5th November 2020

Application No: FG/127/20/PL
Site Address: Onslow Caravan Park Onslow Drive Ferring BN12 5RX
Description of works: Retrospective application for the demolition of 3 No. existing buildings & erection of replacement workshop & machinery store building (amended design & siting to FG/37/17/PL). This site is in CIL Zone 5 (Zero Rated) as other development.

Thank you for your internet representation made on 4th November 2020 which has been recorded as an objection with the comments as follows:

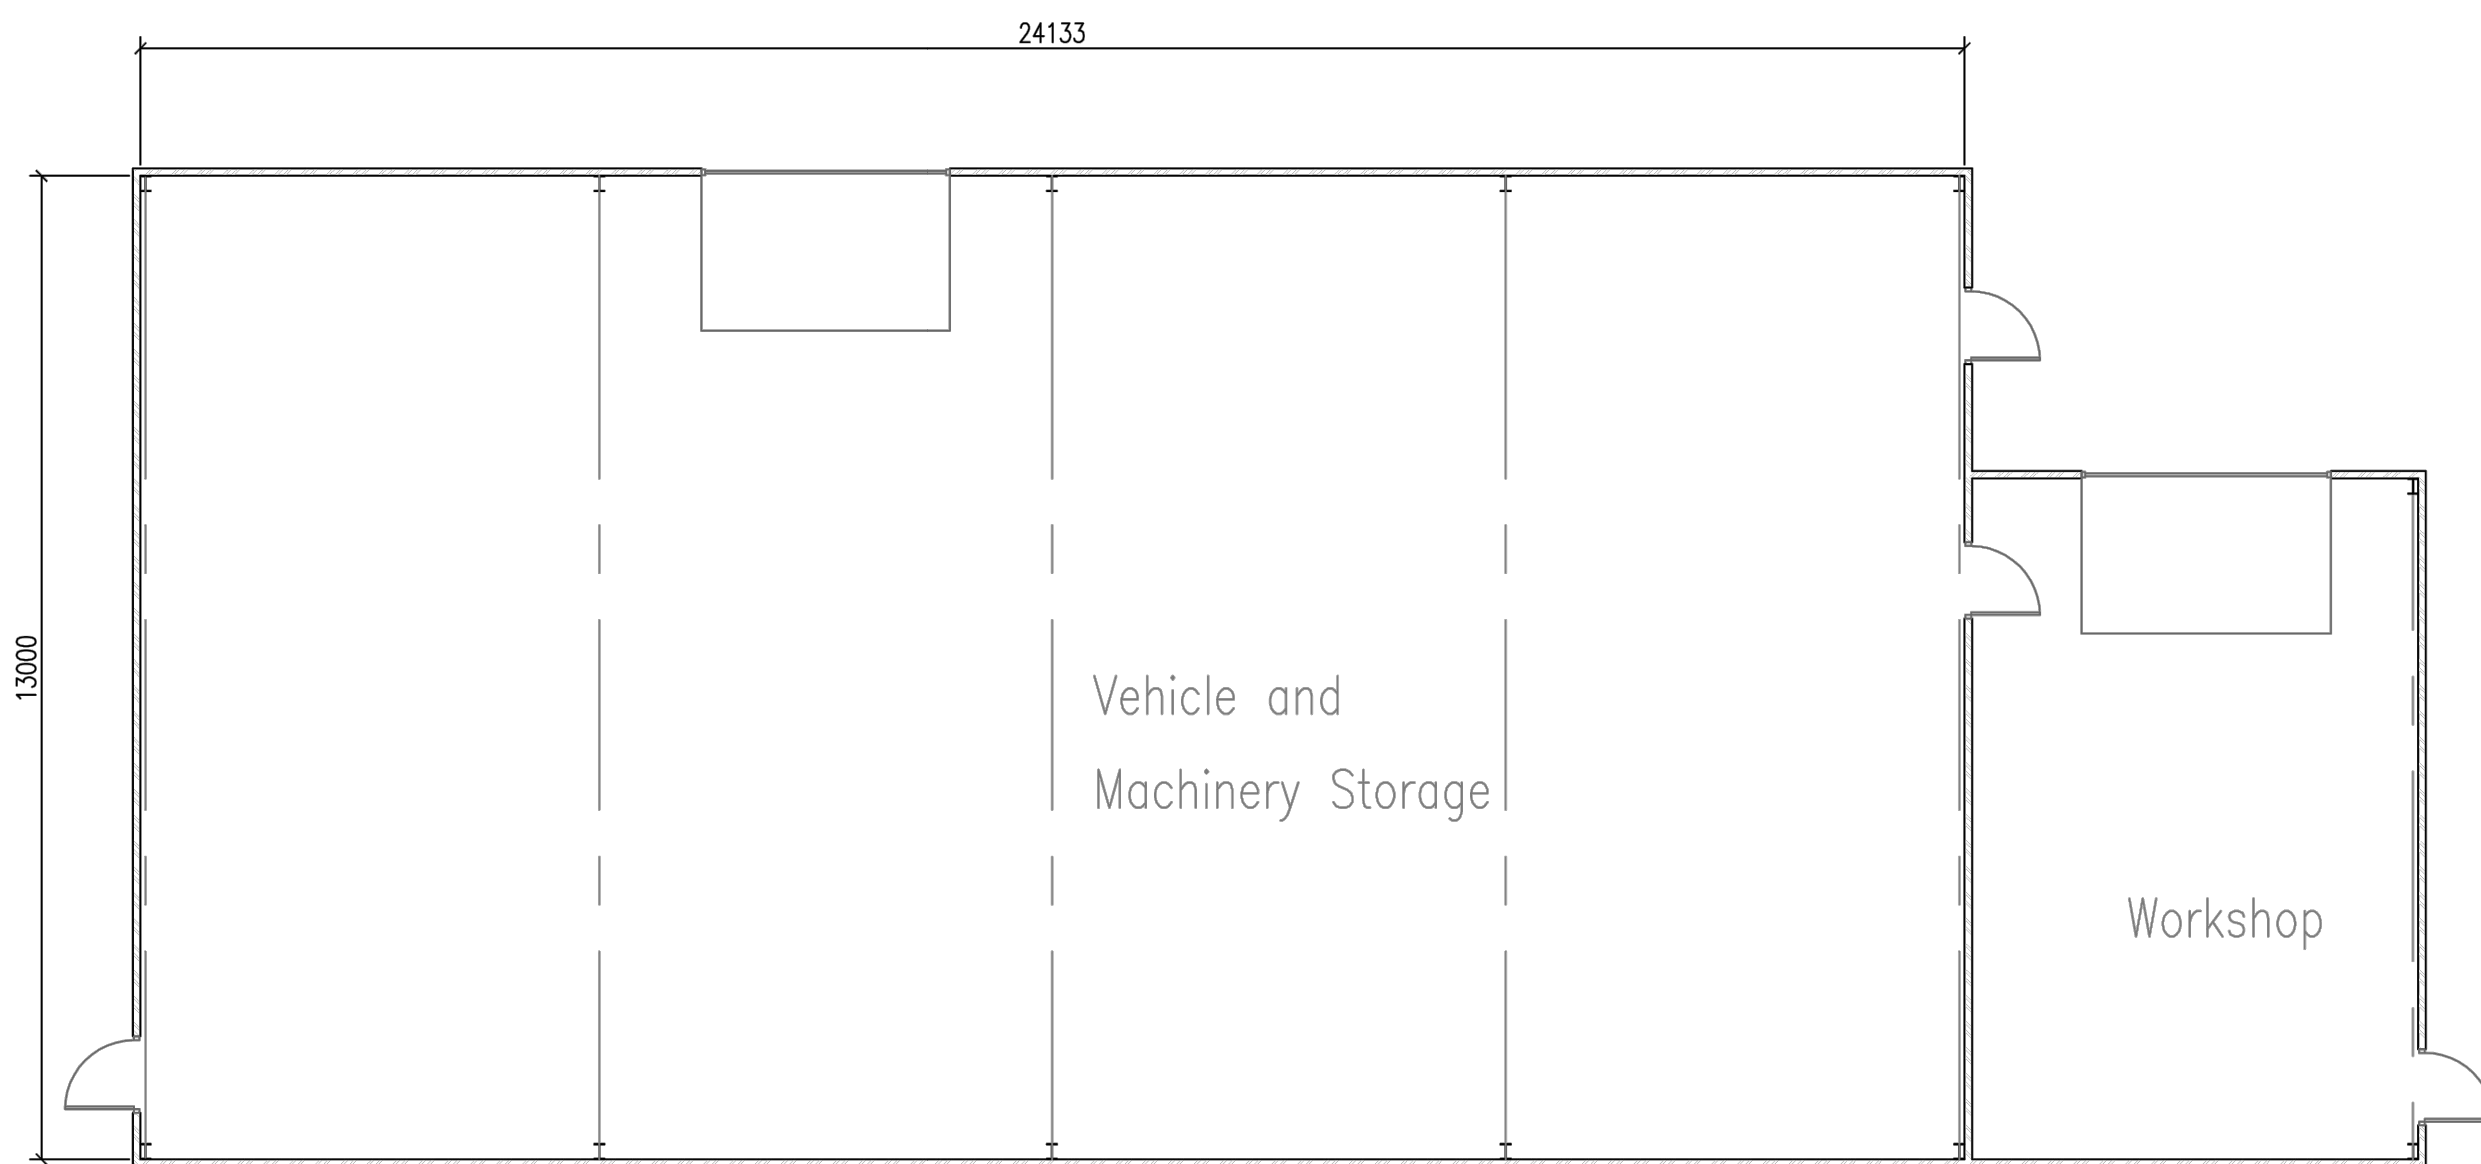
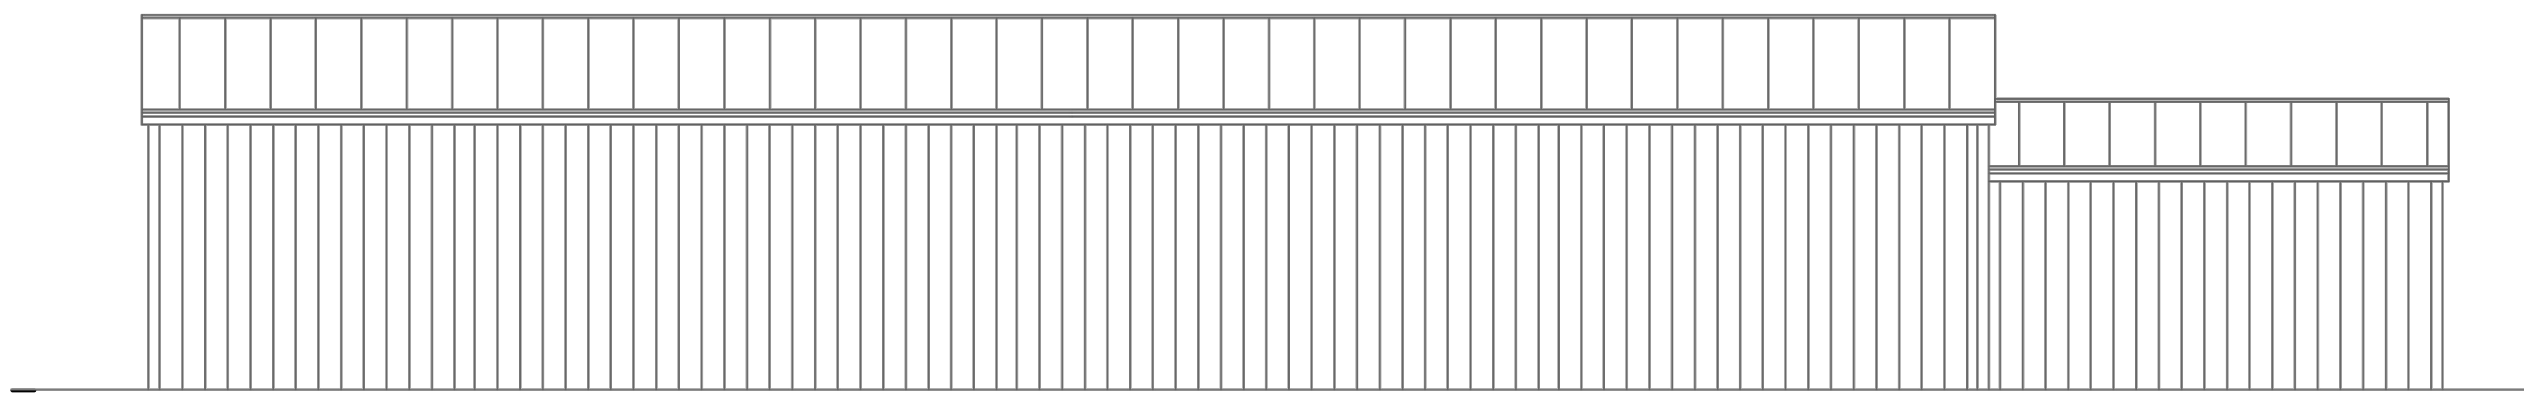
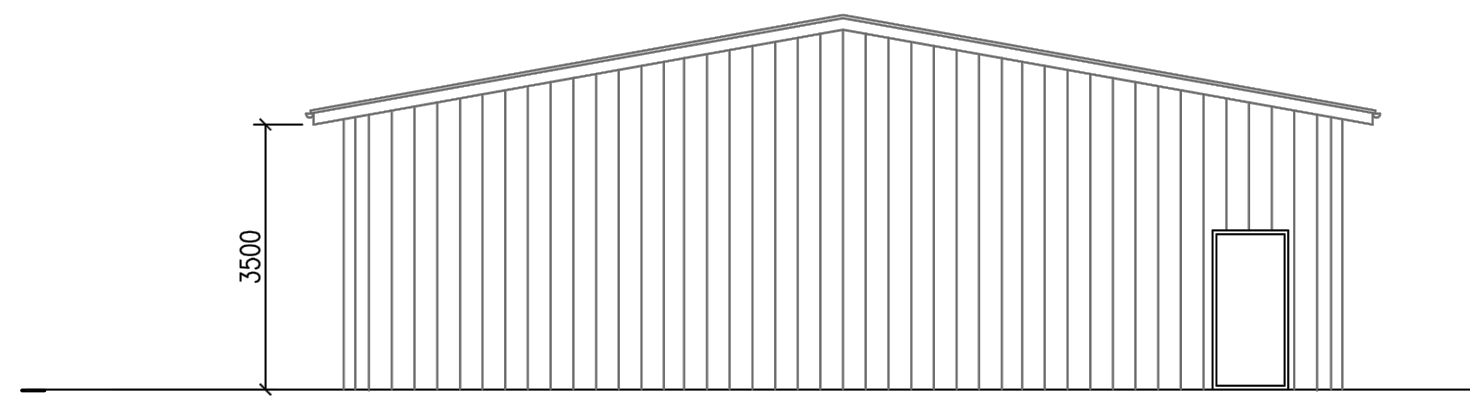
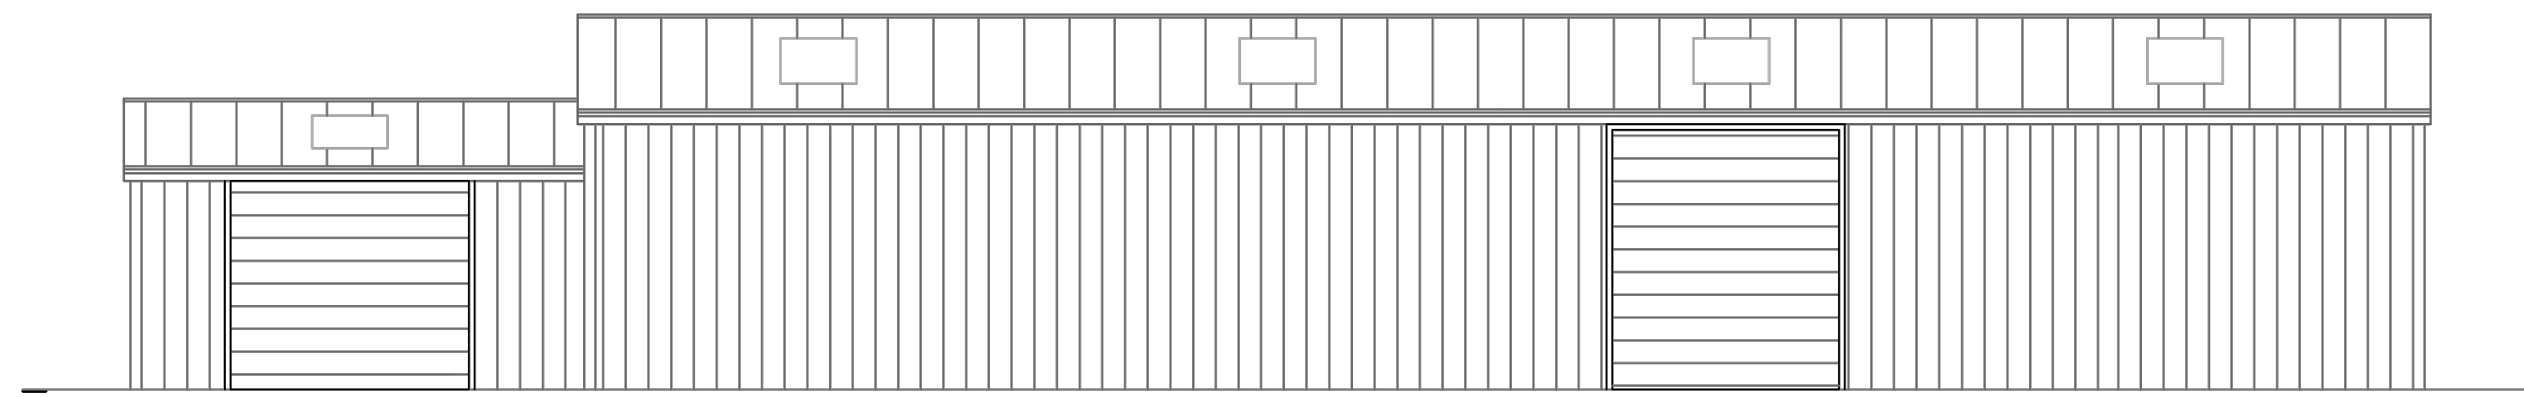
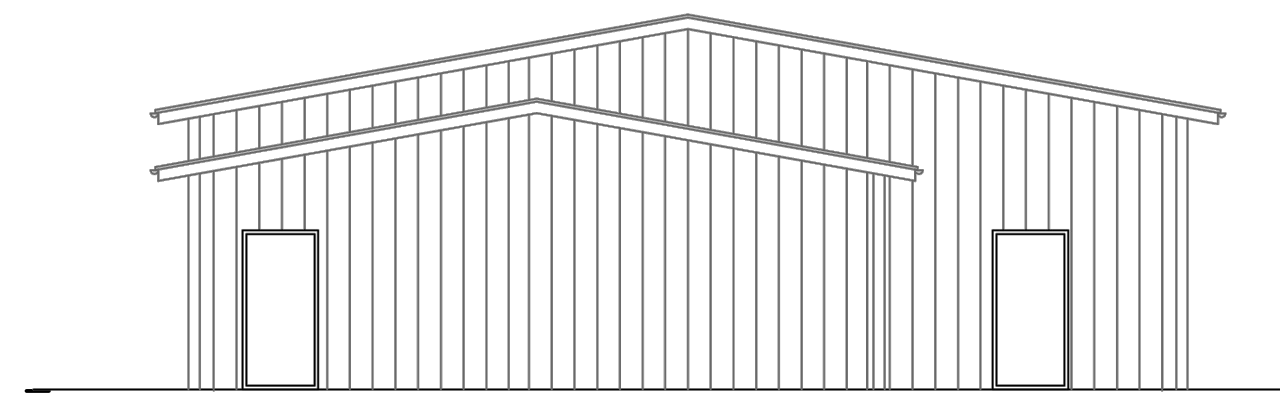
This proposal has been the subject of several planning applications over the years with refusals in 2014 and permission for a scheme granted in 2017. While the permission for the general style, location and usage of the building has already been granted, specific conditions were imposed on the ridge height due to the overall size, mass and height otherwise having an unreasonable and overbearing impact on neighbouring properties.

Despite these various applications and refusals on those specific grounds previously, the structure now has a ridge height exceeding not only the granted submission but also exceeding the previously refused application. The ridge height being a crucial factor in the previous decision this has now been grossly flouted to the detriment of the amenity value of the neighbouring resident's gardens and outlook without any attempt at justification.
